# Tween Bridge Solar Farm

## 9.13 Statement of Common Ground with South Yorkshire Fire & Rescue Service

**Document Reference: 9.13**

**Revision 2**

Figure 2.9: Indicative Layout and Cross Section Plans
Drawing Ref: Typical Hammerhead Turning

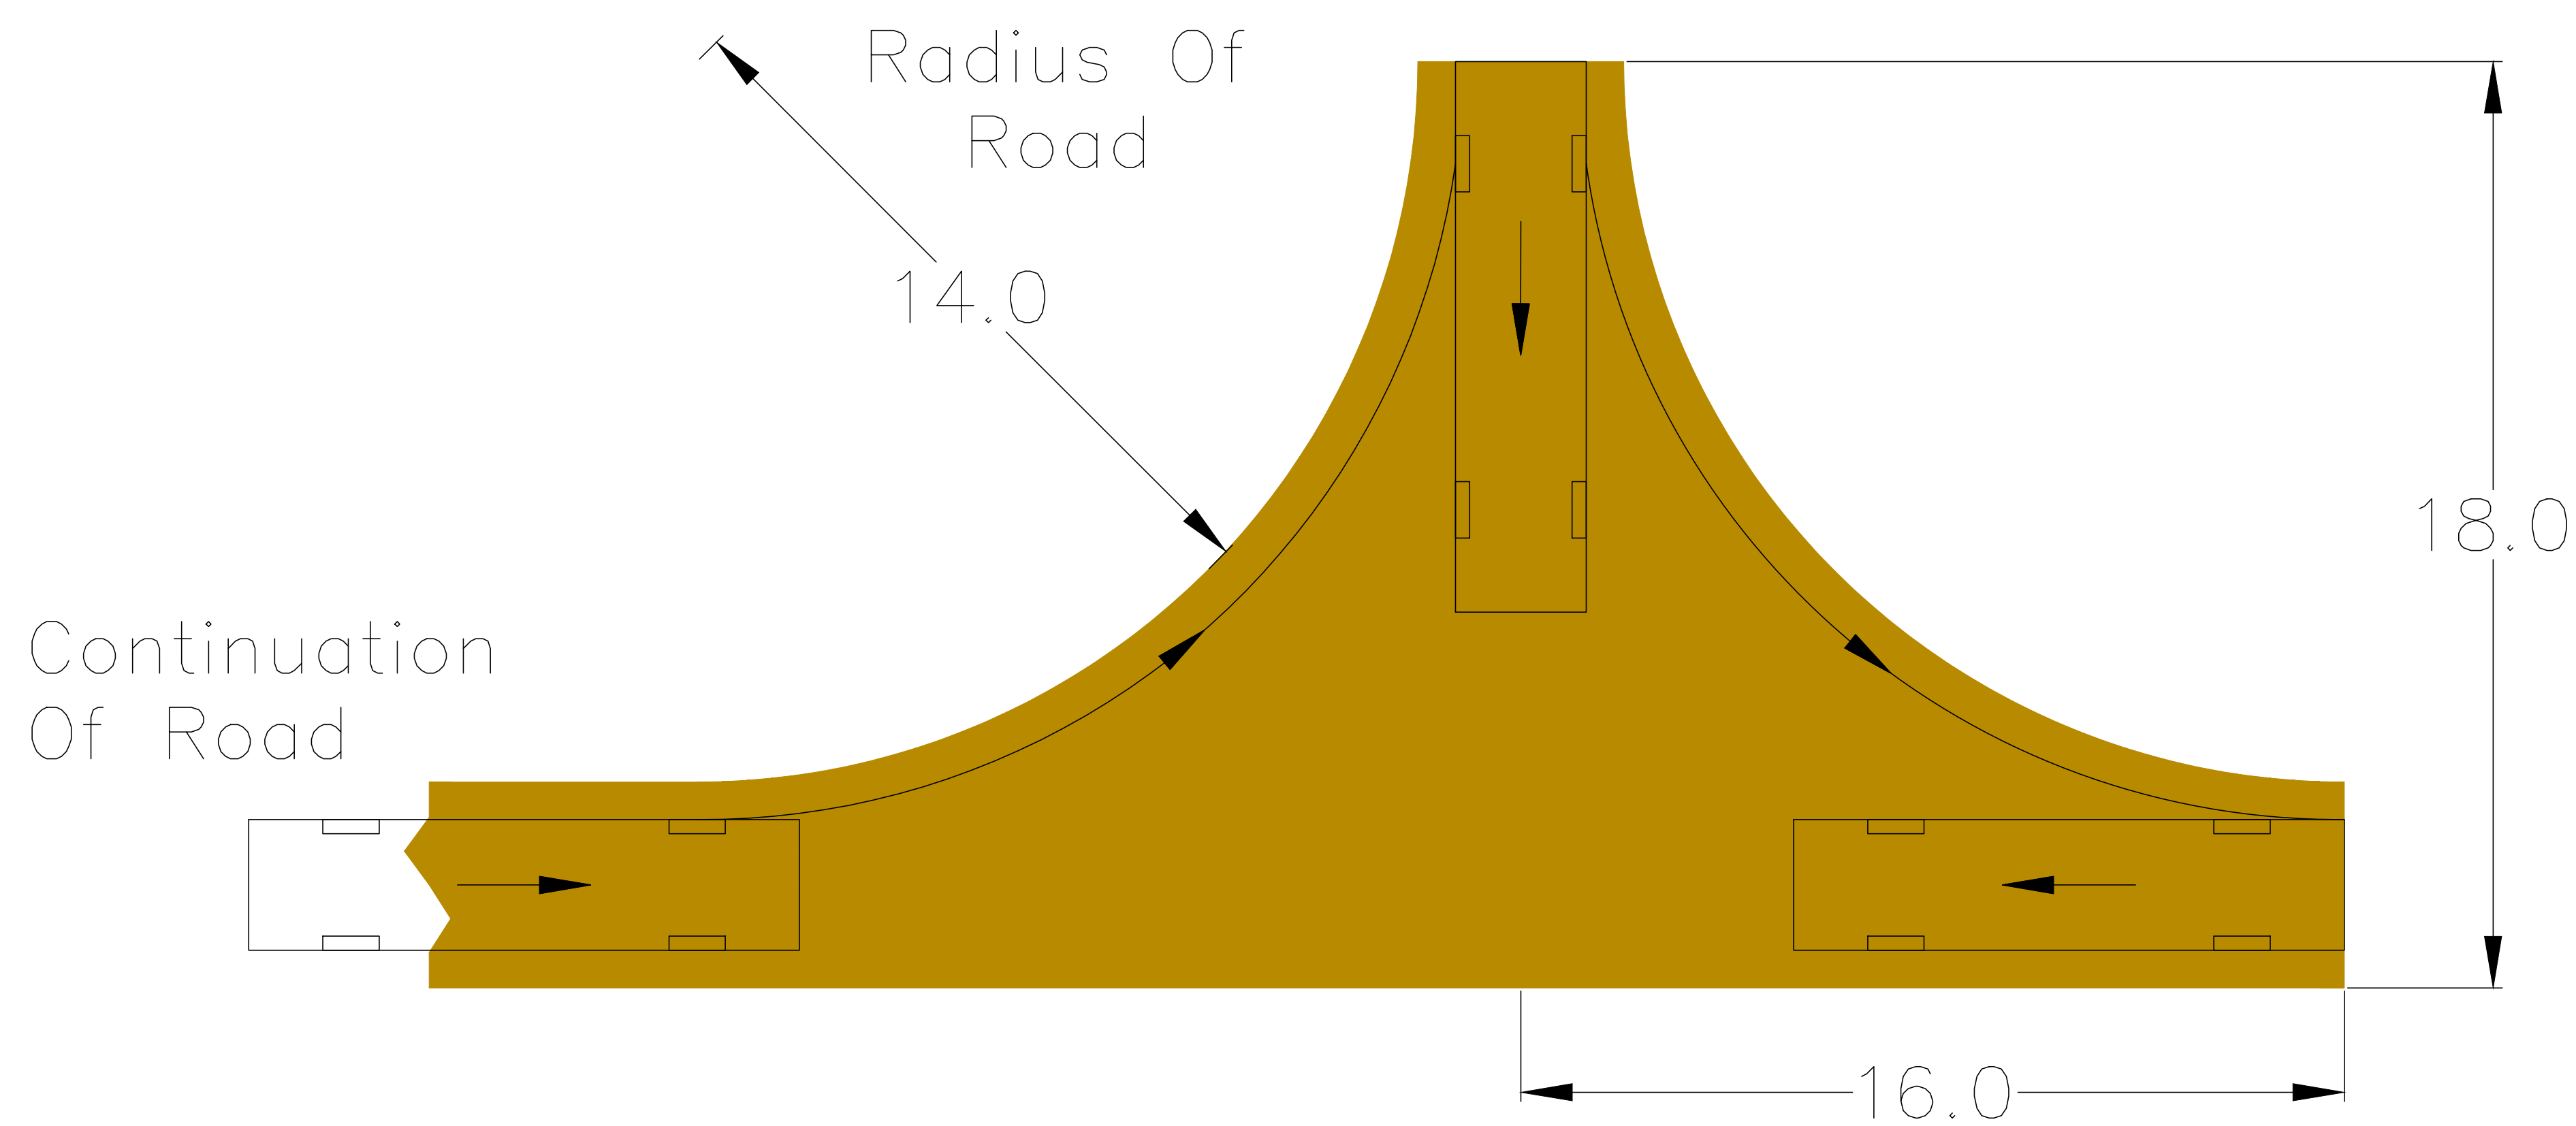
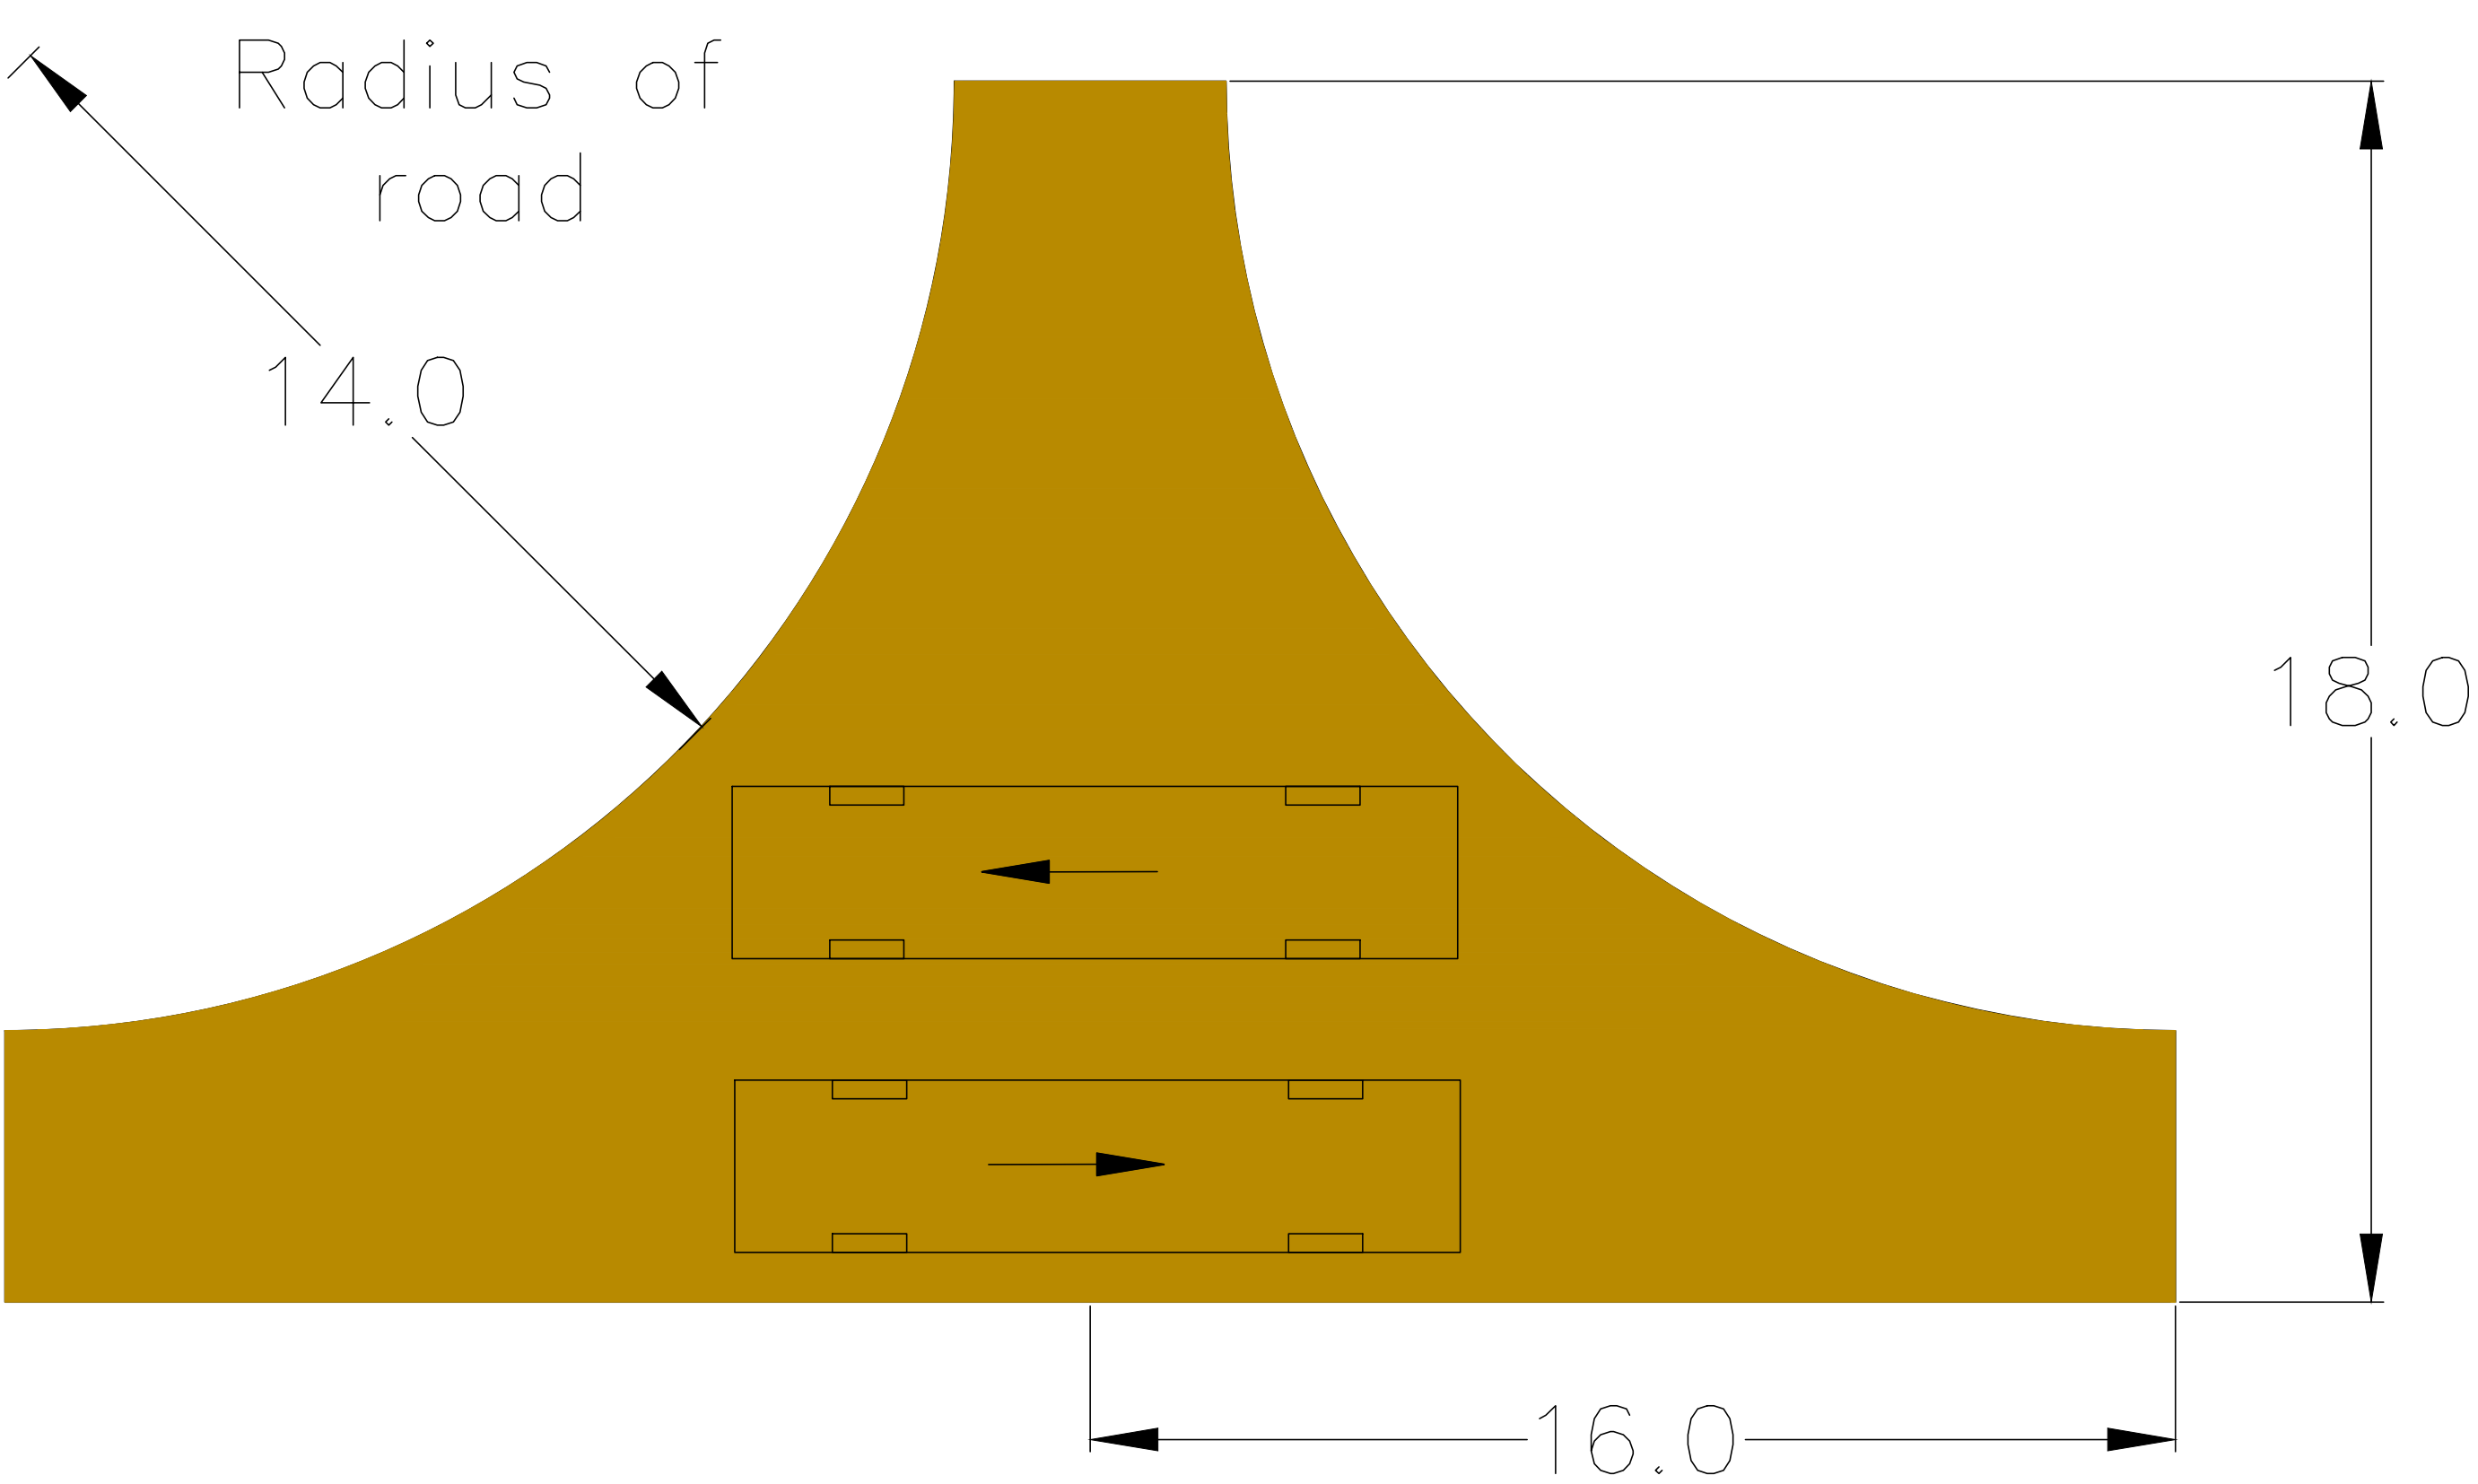
SYFR 4	Site Access	<p>The NFCC guidance states at least 2 separate access points to the site to account for opposite wind conditions/direction. Firefighters should not have to enter the BESS site or drive through a vapour / gas cloud to reach the scene of operation, therefore an alternative access point, taking into account wind direction, is preferable.</p> <p>The principles contained within Approved Document B, in support of B5 may assist in providing proportionate and adequate provision of access and facilities for firefighting. Section 15 provides information relating to access routes and hardstanding areas that consider the dimensions of fire service vehicles.</p> <p>Where access is over 20m from the access road, a turning circle, hammerhead or other point at which a vehicle can turn should be provided. Road / hard standing should be suitable to accommodate fire service vehicles in all weather conditions.</p> <p>Appliance dimensions are variable and designers should take account of this.</p> <p>SYFR appliance dimensions for the current fleet are as follows:</p>	<p>The Scheme is compliant with NFCC guidance as confirmed in the <b>Outline BSMP [Document Reference 7.4 Revision 2]</b>.</p>	Agreed

Type	Turning Circle (Metres)	Front Axle (kg)	Rear Axle (kg)	Height (Metres)	Length (Metres)	Width (Metres)	Weight Gross (kg)
Scania Rescue Pump	<17	6152 kg actual 7500 kg MAM	8086 kg actual 11500 kg MAM	3.33	8.7	2.5 including mirrors 3.0	14500kg actual 18000kg MAM
Scania Turntable Ladder	<19	6,356 kg actual 8500 kg MAM	10120 kg actual 11500 kg MAM	3.50	10.5	2.55 including mirrors With jacks deployed 4.84	16476 kg actual 18000kg MAM
